Dear Ms Willard,
PLANNING APPLICATION NUMBER: P/43/19/HH
DETACHED GARAGE AT 7 DRIFT ROAD, NYETIMBER, BOGNOR REGIS.

1 : 100

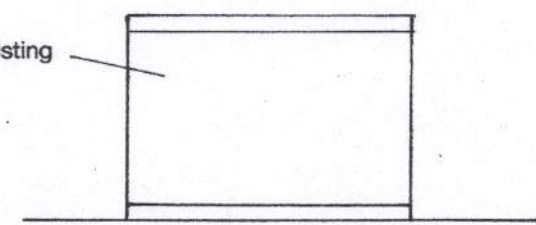
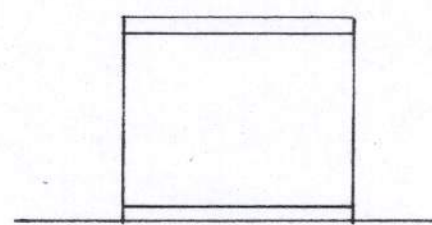
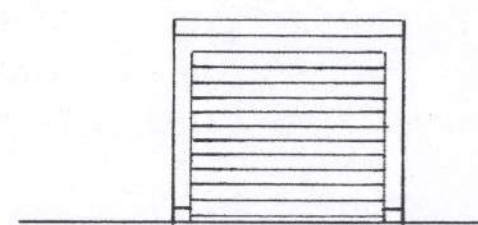
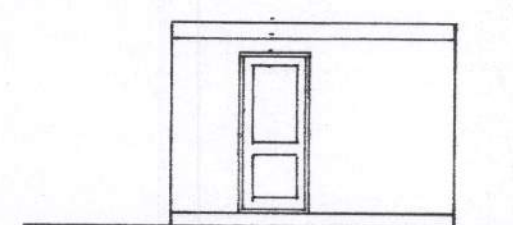
2/ This structure would reduce the amount of natural light entering my property from a Westward direction though both my front bedroom and living room. It would also cut out my visibility looking towards the Hook Lane end of the road. This view would now consist of the rear elevation and side of a garage, in effect, as if a wall had been built half way across the adjoining property's garden. The same would apply to the light and view to number 5 as it looked over towards Leonora Drive and number 11 as it looked towards Hook Lane.

Plan

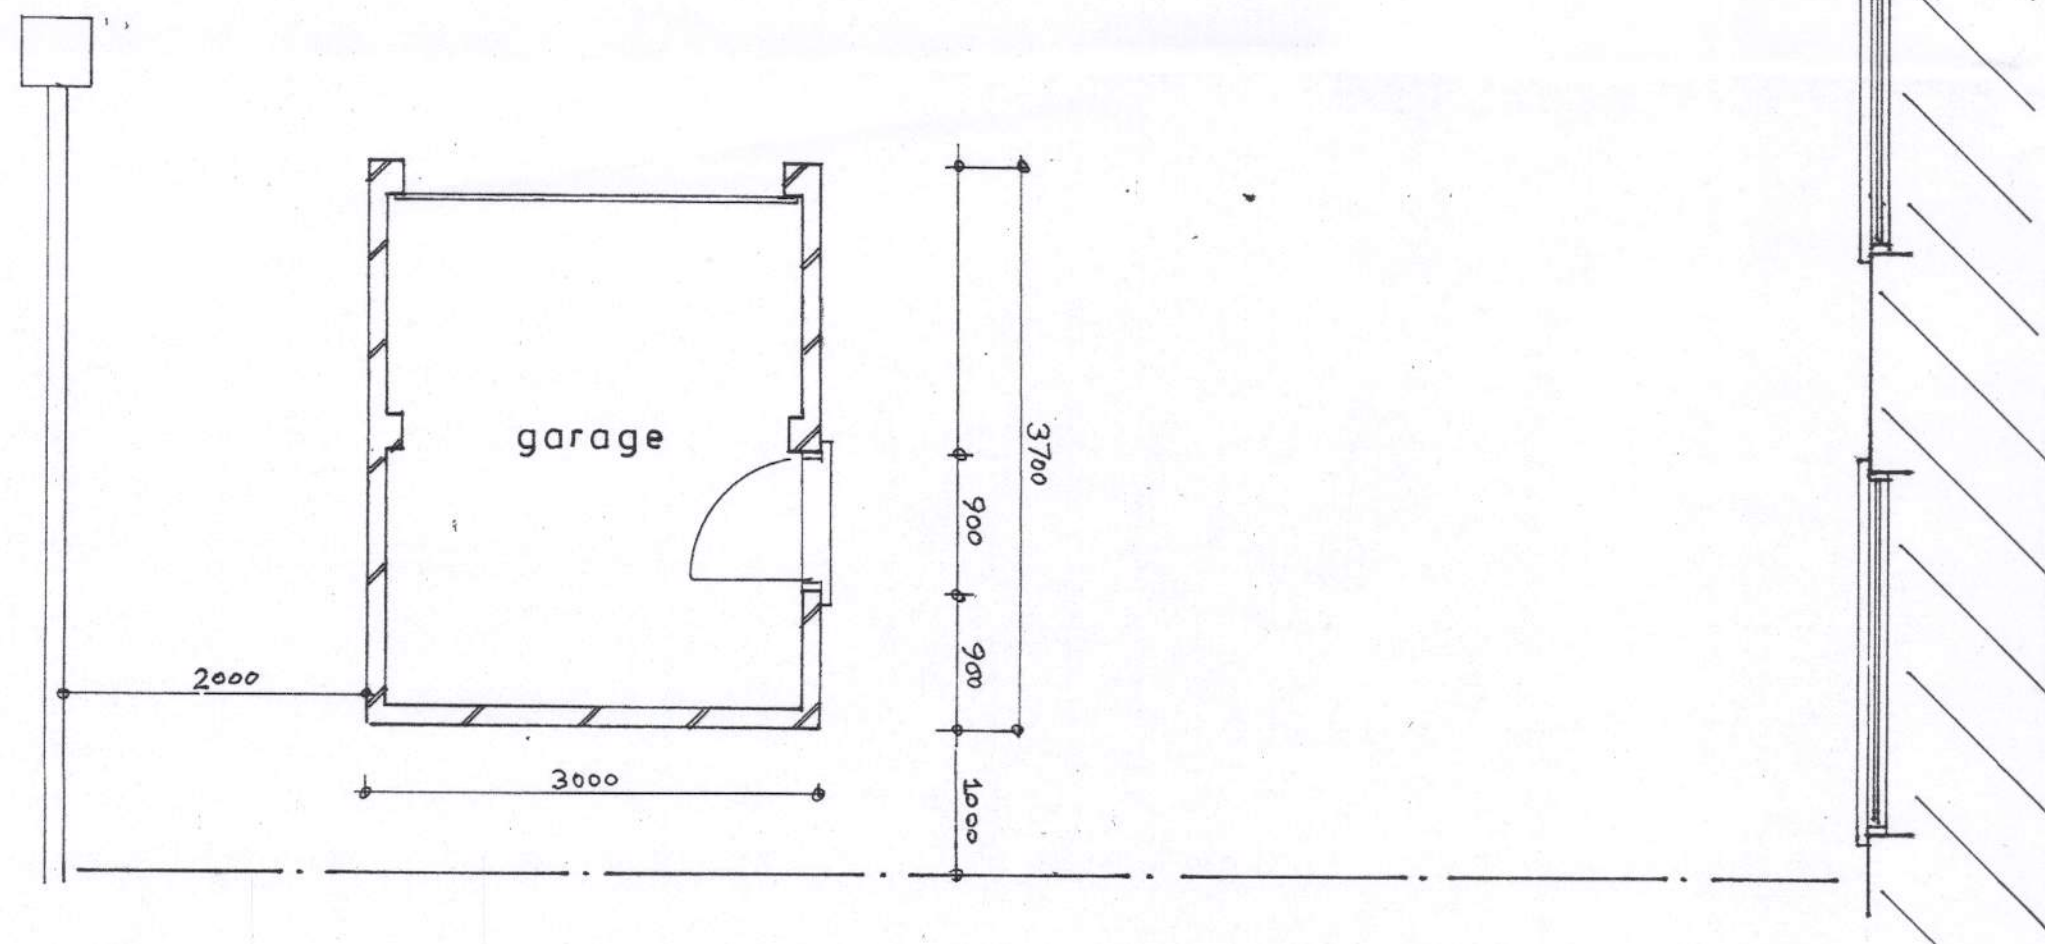
4/ On viewing the plans for the garage I'm unclear as to which building line it follows. It appears to have been placed at 2 metres from the front boundary wall. I can see nothing in the form of an existing structure that this position relates to.

Looking at the plan it is highly unlikely in my opinion that a vehicle would be able to enter this garage leaving open as to what other use this building may be put to.
